CITY OF ALBUQUERQUE

June 16, 2016

Re: Jackson Middle School
10600 Indian School Rd., NE
Traffic Circulation Layout
Engineer's/Architect's Stamp **6-15-16** (J21-D029)

TCL-101

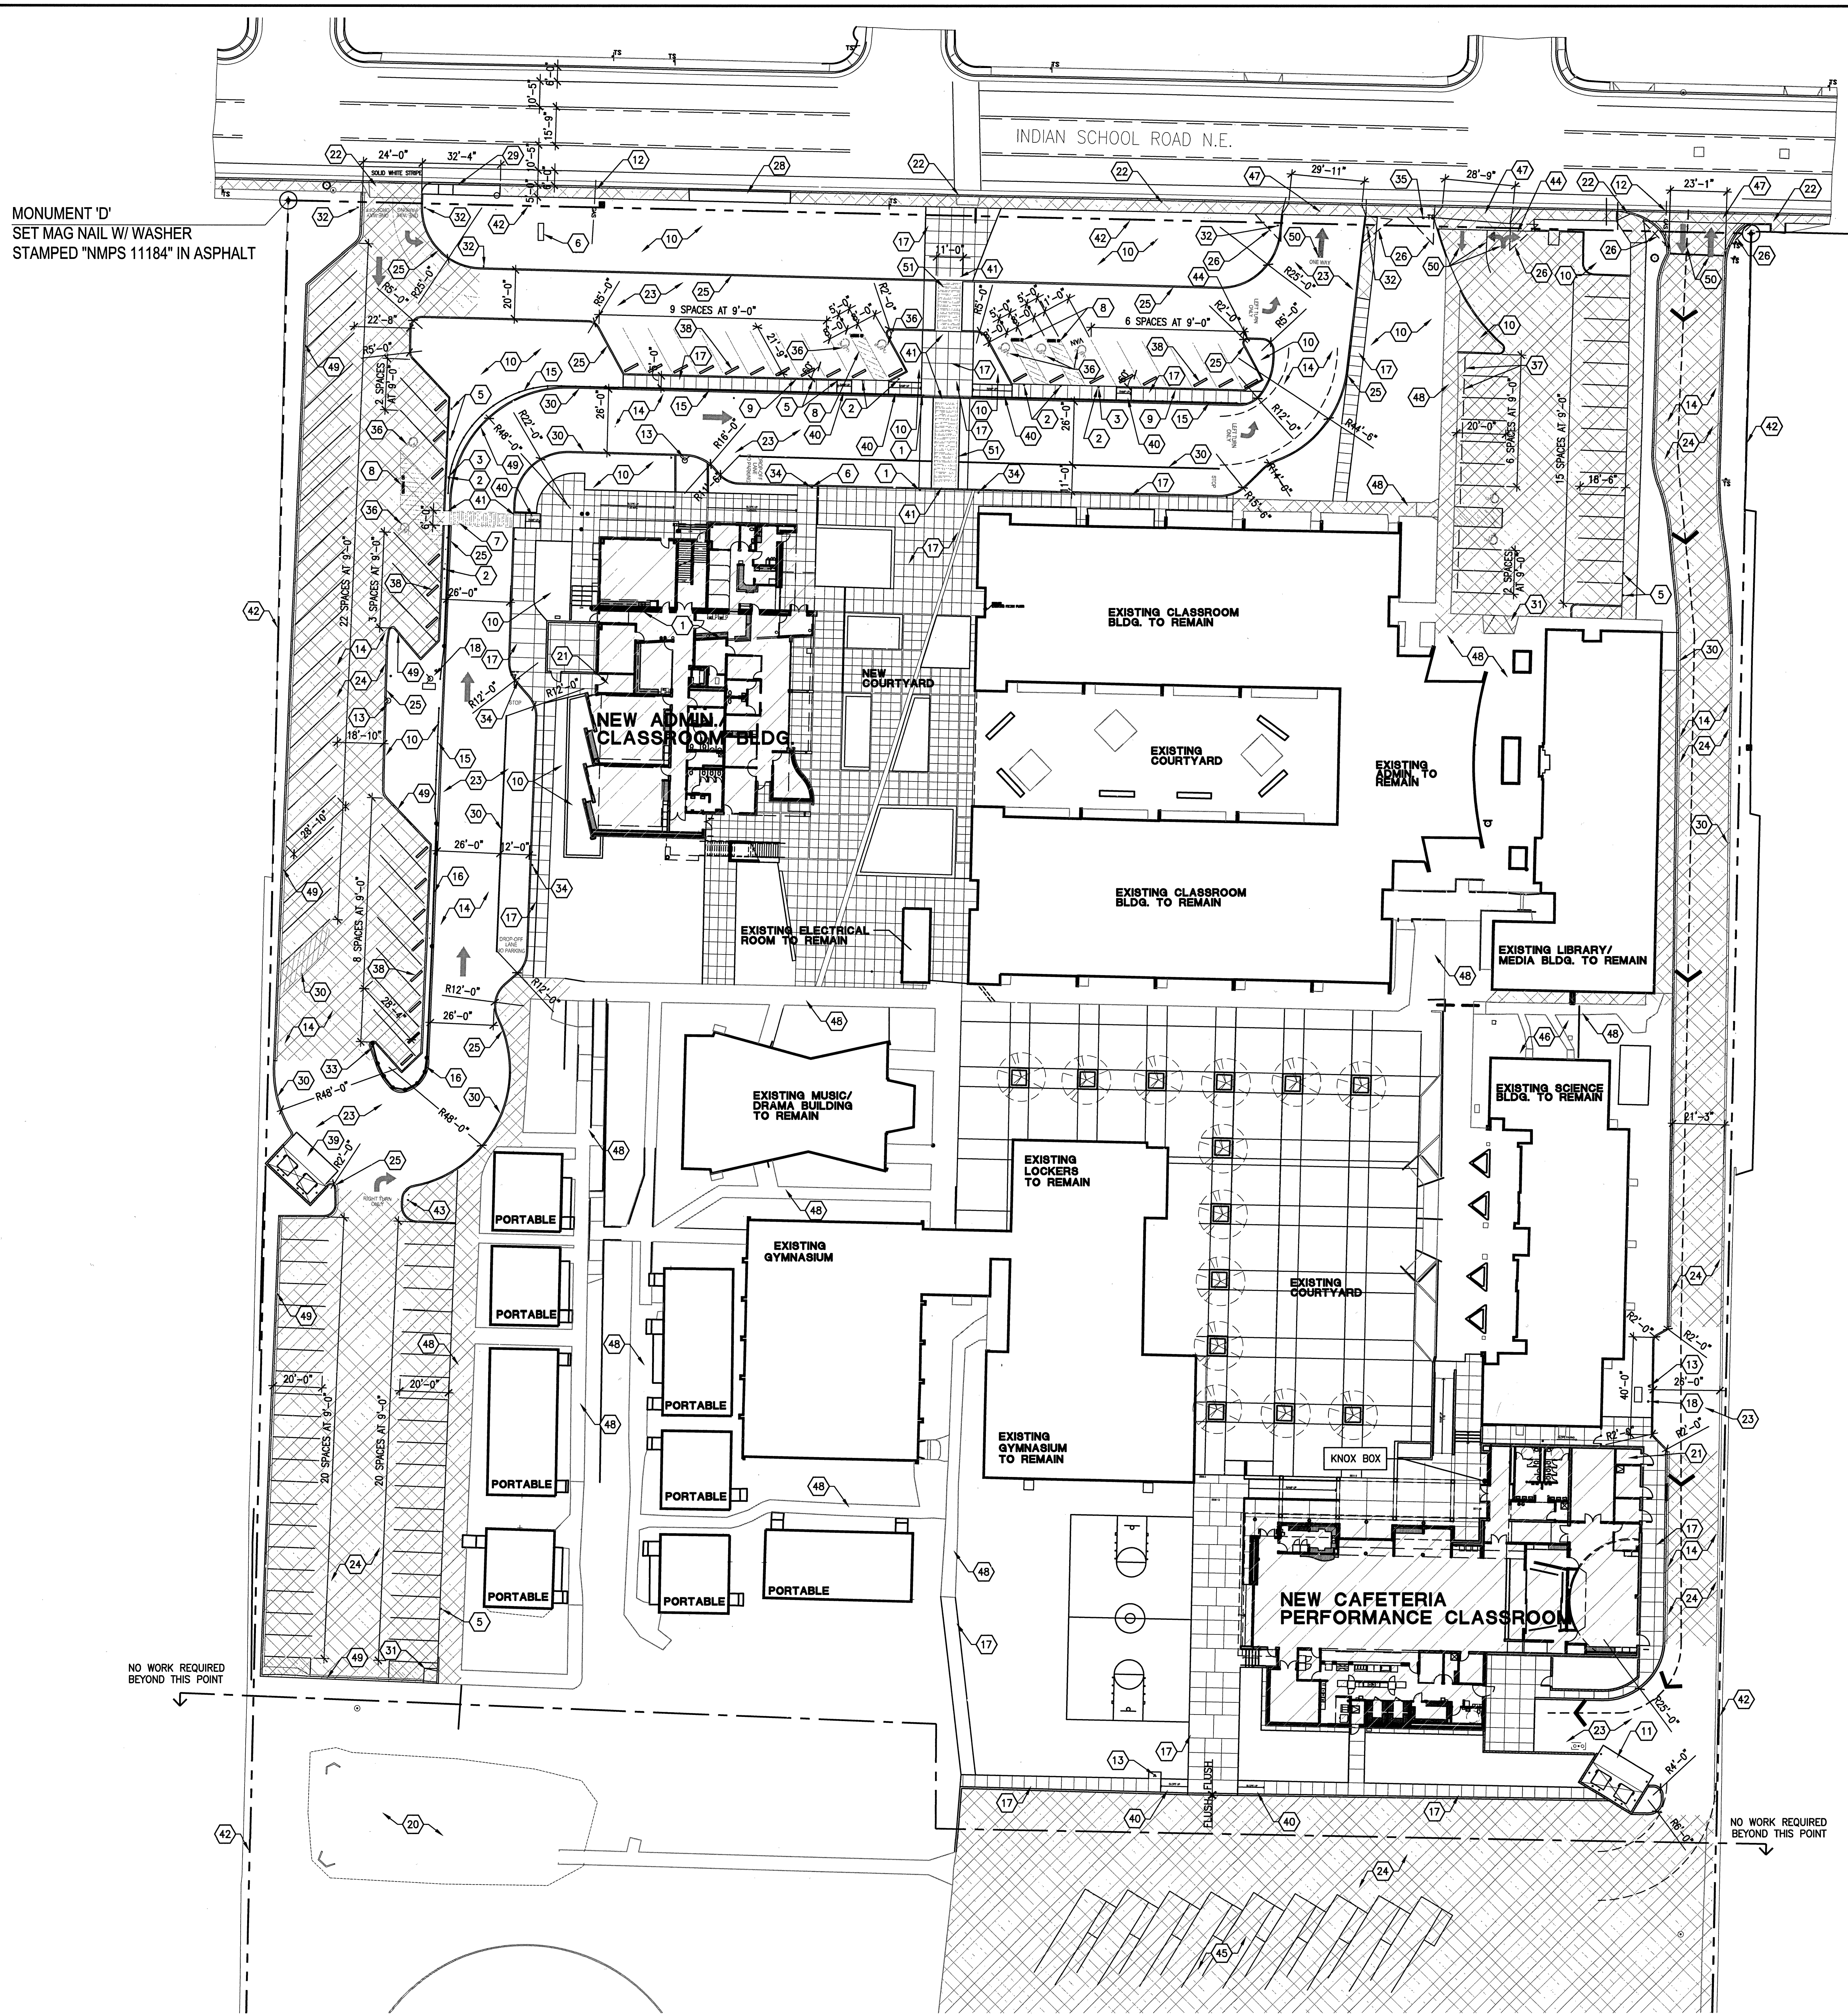
1. List the number of parking spaces required by the zoning code as well as the proposed number of parking spaces.
2. Please identify all existing and proposed sidewalks, curbs, drive pads ADA ramps and anything that influences the parking and circulation on the site.

3. Identify all existing access easements and rights of way width dimensions.
4. Identify the right of way width, medians, curb cuts, and street widths on Indian School Rd.

5. Please detail and dimension proposed new drive pads, sidewalks, curb and gutter improvements at the northwest entrance and clearly detail the drive pads for the one-way exit and employee parking entrance on the northeast portion of the project site. Clearly show drive pads and dimensions of drive pad extensions.

6. Please list the width and length for all existing and proposed parking spaces. Include the parking spaces, HC parking pedestrian pathways south of the proposed new Cafeteria and Performance Classroom.

7. The ADA accessible parking sign must have the required language per 66-7-352.4C NMSA 1978 **"Violators Are Subject to a Fine and/or Towing."** Please call out detail and location of HC signs.

8. Per DPM, a 6 ft. wide ADA accessible pedestrian pathway is required from the public sidewalk to the building entrances. Please clearly show this pathway and provide details from Indian School Rd.

9. Per DPM, a 6 ft. wide ADA accessible pedestrian pathway is required from the HC parking stall access aisles to the building entrances. Please clearly show this pathway and provide details from all HC parking spaces. In review of the submitted drawing, the pathway on the north side of the proposed new Admin./Classroom Addition only provides a 5 ft. pathway from the HC parking spaces.

10. Service vehicle and/or refuse vehicle maneuvering must be contained on-site; provide a copy of refuse approval.
11. Please provide a sight distance exhibit (see the *Development Process Manual, Chapter 23, Section 3*). Please dimension the Clear Sight Triangle called out in Note # 26.

12. Please add the following note to the clear sight triangle: "Landscaping and signage will not interfere with clear sight requirements. Therefore, signs, walls, trees, and shrubbery between 3 and 8 feet tall (as measured from the gutter pan) will not be acceptable in this area."

13. Please specify the City Standard Drawing Number when applicable.
14. Please add a note on the plan stating "All improvements located in the Right of Way must be included on the work order."

15. Unused curb cuts must be replaced with sidewalk and curb & gutter. A build note must be provided referring to the appropriate City Standard drawing.

16. All broken or cracked sidewalk must be replaced with sidewalk and curb & gutter. A build note must be provided referring to the appropriate City Standard drawing.
